Planning Application Ref: BE/19/21/T

Location: Arun Retail Park, Shripney Road, Bognor Regis, PO22 9NF

Description of works: Various Works to various trees within retail park

Q161-01 Tree Survey Plan

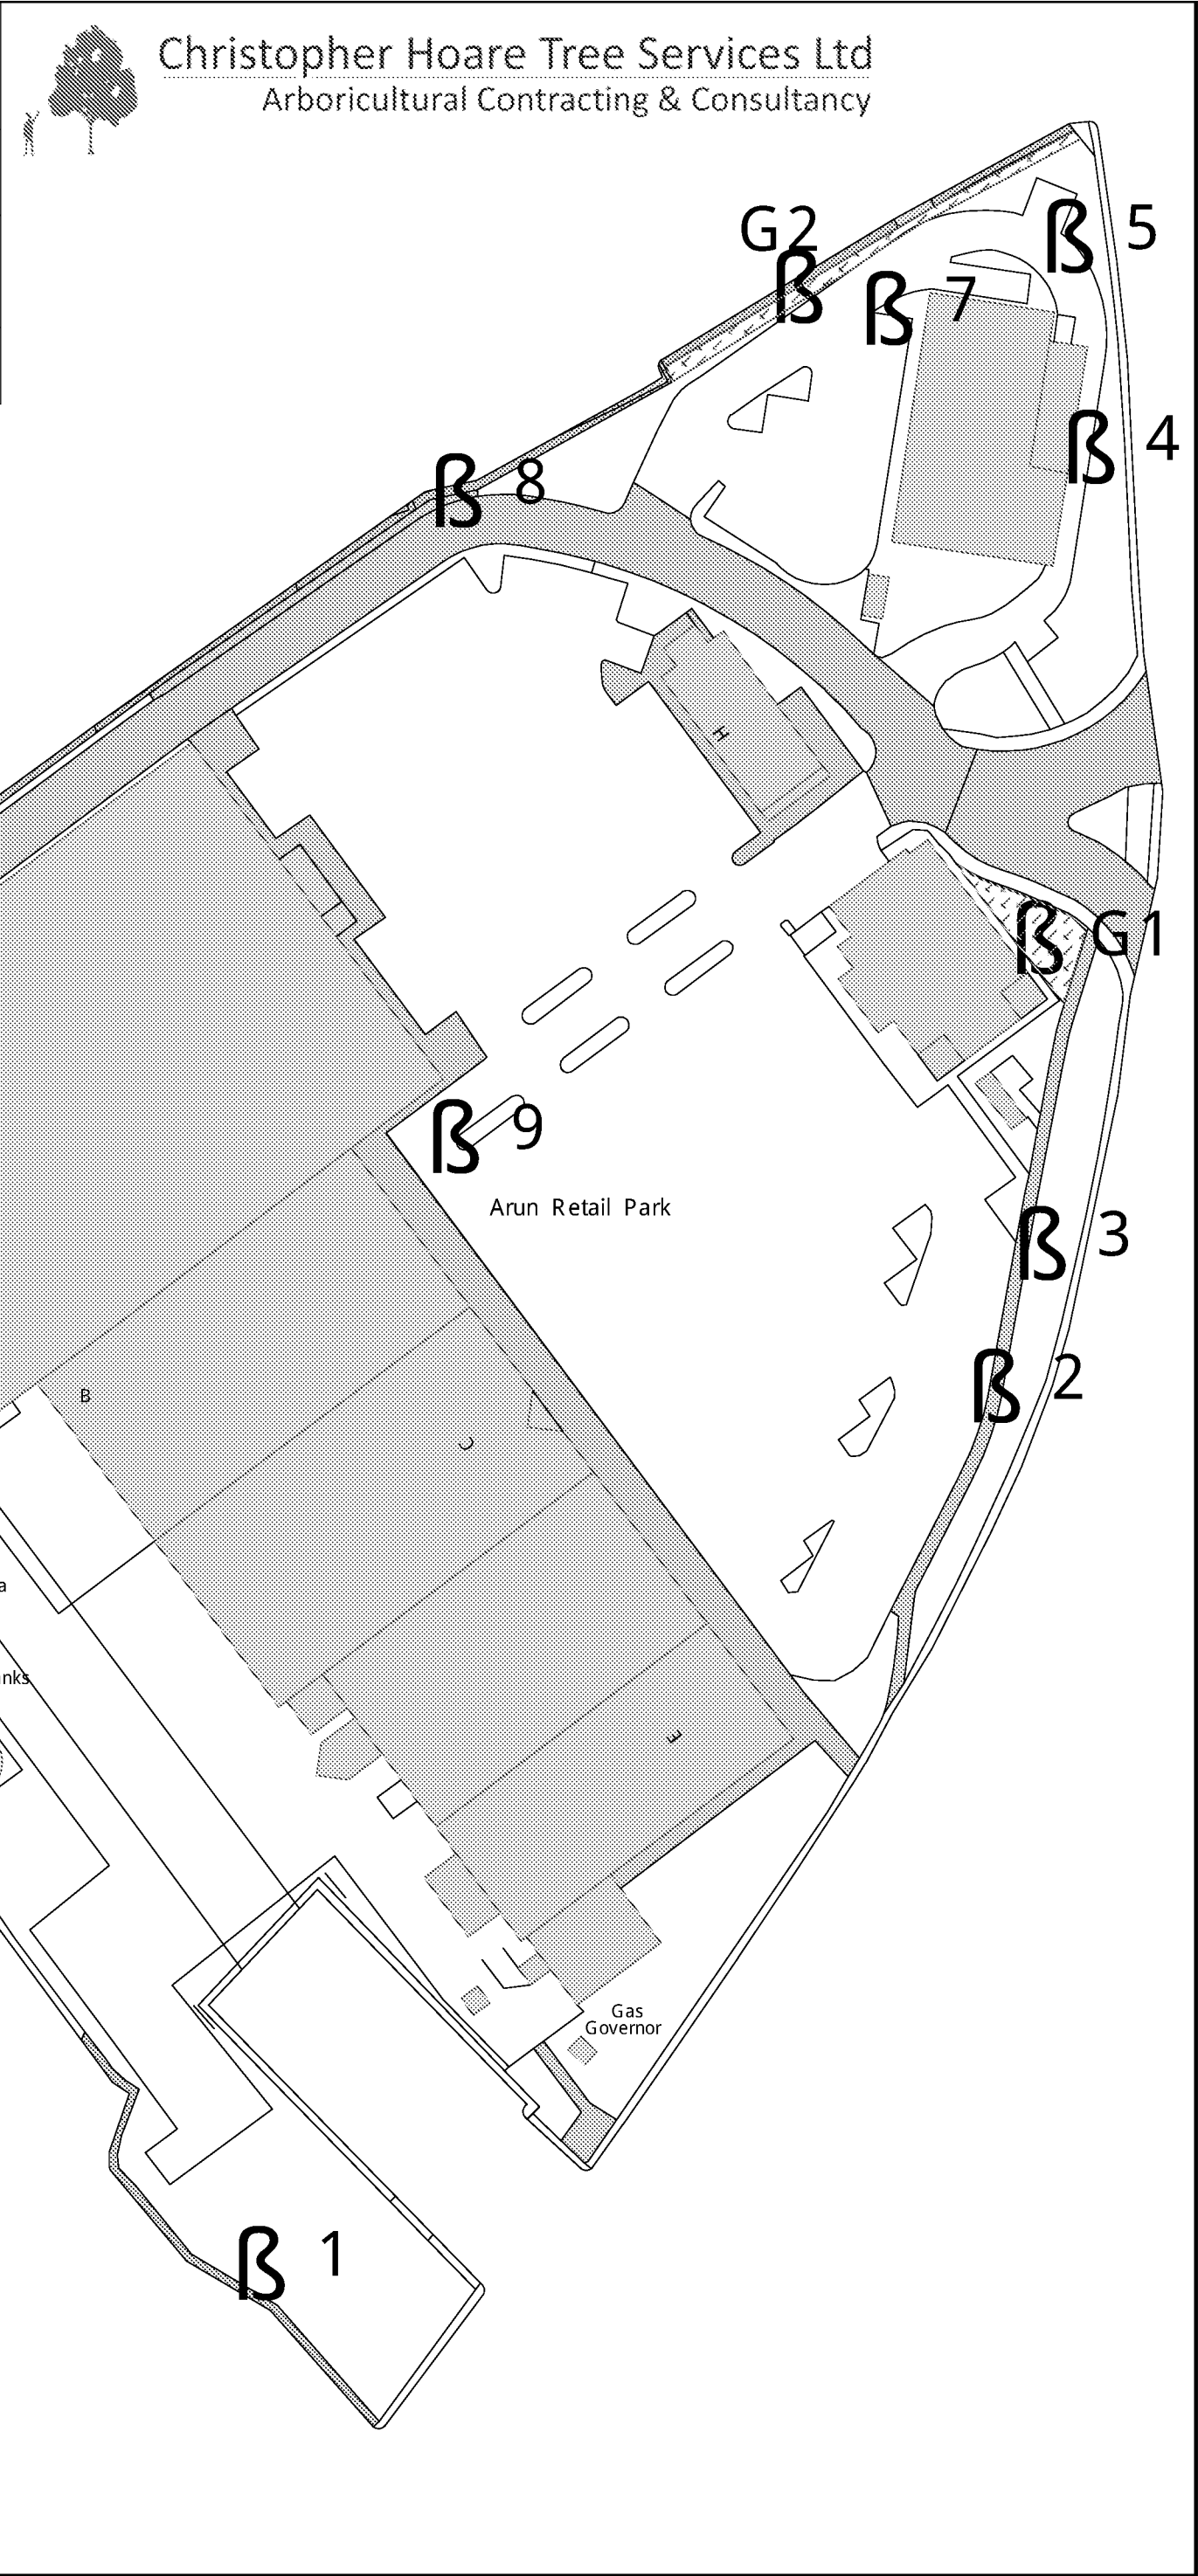
T2 White willow / *Salix alba* Height: 10-15m, Radial spread: 5-10m, Age class: Mature

T3 Horse chestnut / *Aesculus hippocastanum* Height: 10-15m, Radial spread: 5-10m, Age class: Mature

- My understanding is that only TPO/BE/1/94 affects the above site. Having considered the supporting Schedule and Plan, only items T2 and T3 in the applicant's Tree Survey are subjects of that Order. The remaining items listed in the Tree Survey are to receive general maintenance pruning and I do not consider it necessary for any of those to be made the subject of a new Order.

- T2 - Outwardly this tree appears to be in a fine physiological state and relatively stable. It is prominent and highly visible to highway and retail park users. It has an obvious pruning history (crown reduction). Repeat operations such as now being asked for will be necessary throughout the remaining lifespan of this tree, to achieve a reasonable degree of structural integrity appropriate for its location.

- T3 - Outwardly this tree appears to be in a fair physiological state and relatively stable although clearly diseased and with reduced safe, useful life expectancy. It is prominent and highly visible to highway and retail park users.

- The work proposed is justified on arboricultural grounds.
- T2 - While a temporary loss of aesthetic value is inevitable, satisfactory canopy renewal and recovery should occur if the work is undertaken to a high standard and at an appropriate time of year.
- T3 - The work proposed is necessary to mitigate risk of potentially catastrophic structural failure. Replacement planting with a tree of suitably large dimensions at maturity can be secured by condition.

Once the horse chestnut tree (T3) has been felled (and either grubbed or ground out) then a replacement tree is to be planted in the same place or nearby and to within 4metres.

This is to be of Standard Nursery Stock proportions (10-12cm girth & 2m to 3m overall height) supported on a 'short stake' system with appropriate securing ties and pads.

It is to be planted within 12 months of the removal of the horse chestnut tree.
